RE; 2009 1233 Station Inn Darfield.

Thank you for your suggestions and sketch.

Outline planning application for:
2 No. 3 bed semi detached houses with small gardens
and parking spaces for 2 cars each. Each house will
be approximately 120 sq metres over 2 floors.

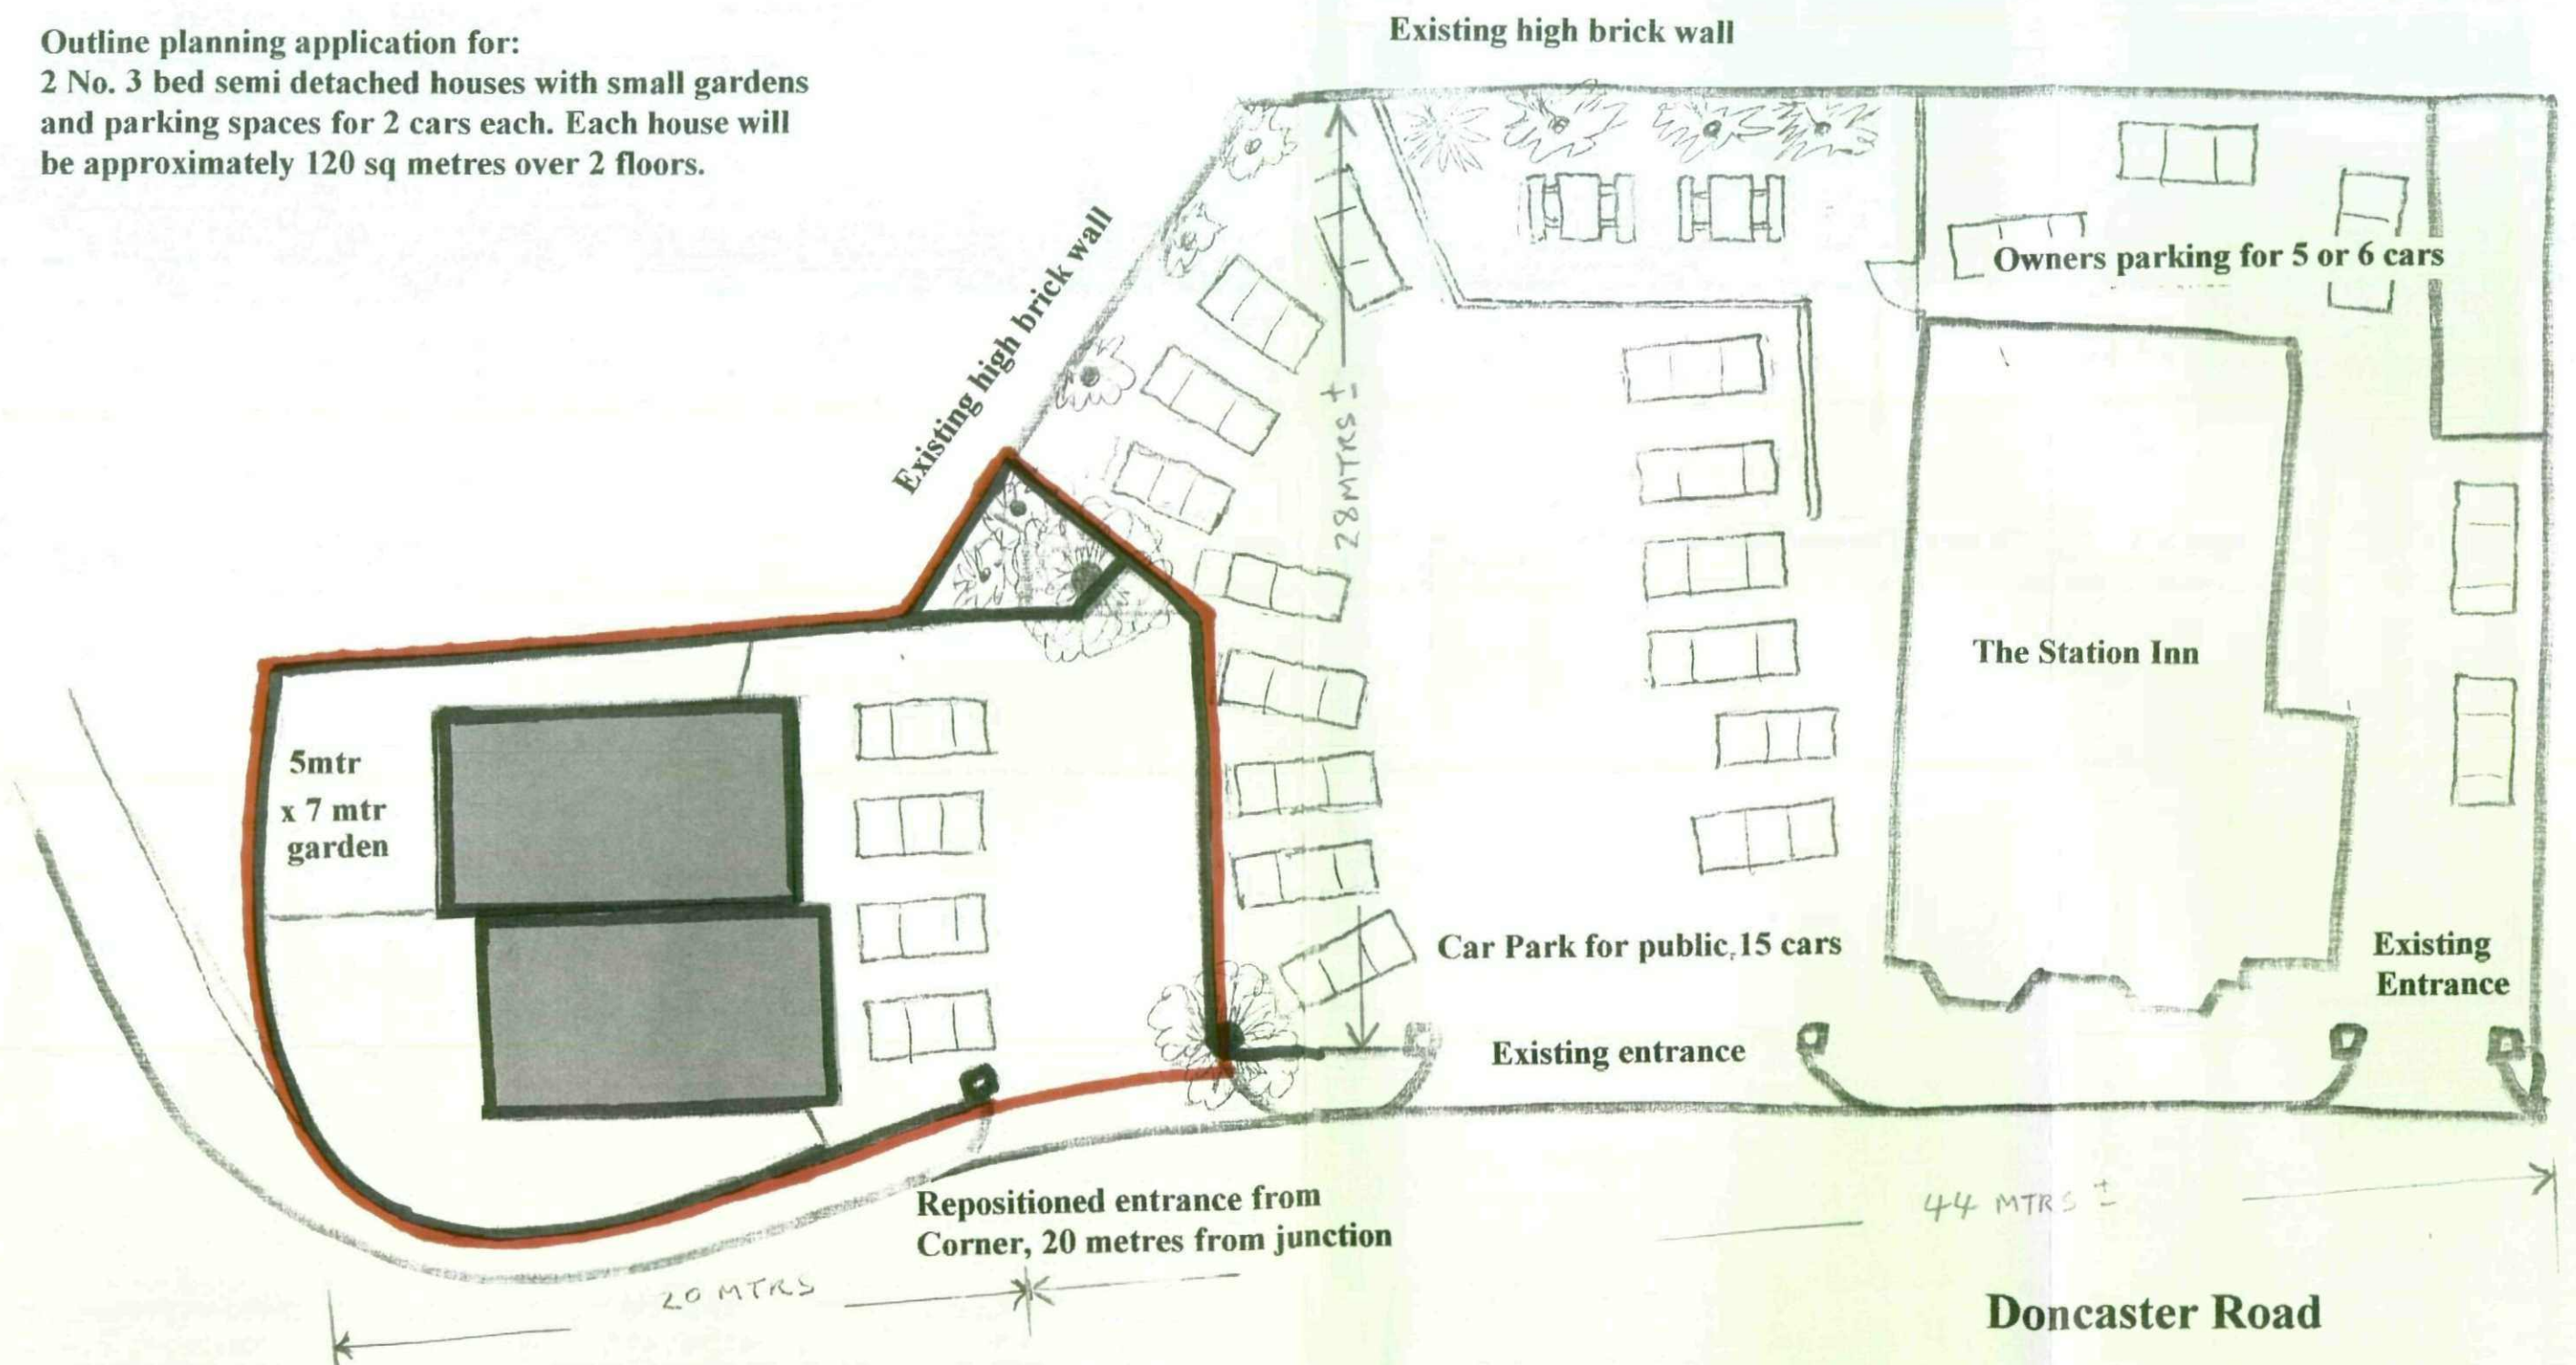
Your sketch suggestion would result in cars having to reverse onto the main road which could cause problems.

I think that you considered it a little far for some to walk from the car park at one end to their home, splitting the car parking areas reduces this distance.

The 2 x 2 bed houses are 12 metres at the closest point to the rear of the nearest overlooking property. This layout does mean that one 3 bed house has a 45 sq. metre garden, which, I hope, would be acceptable for the overall regularity of the run of houses. If not, it would be easy to step the house forward 2 metres to bring the garden up to 53 sq. metres, I have marked this in broken line and welcome your advice regarding that.

Each house would have a 2 x 1 metre flip top bin storage area, this is amply large enough for 3 standard bins, each area would have a ramped down path so that the flip top roof would be at 1 metre height. This is to allow for clear vision from 1.2 metre height kitchen window and so that the roof ties in with the top of the railings along the front brick wall.

The 2 bed houses have their bins storage in the car park alongside.

This layout uses existing road access points and all vehicles car turn within the parking areas to leave the site in forward gear onto the Doncaster road. All car sizes are set at large family estates.

Existing trees along the existing high brick wall would remain for everyone's benefit and each house would have a small front garden area for some shrubs.

Each house would have a front bay window on the ground floor to mirror traditional styles along the road.
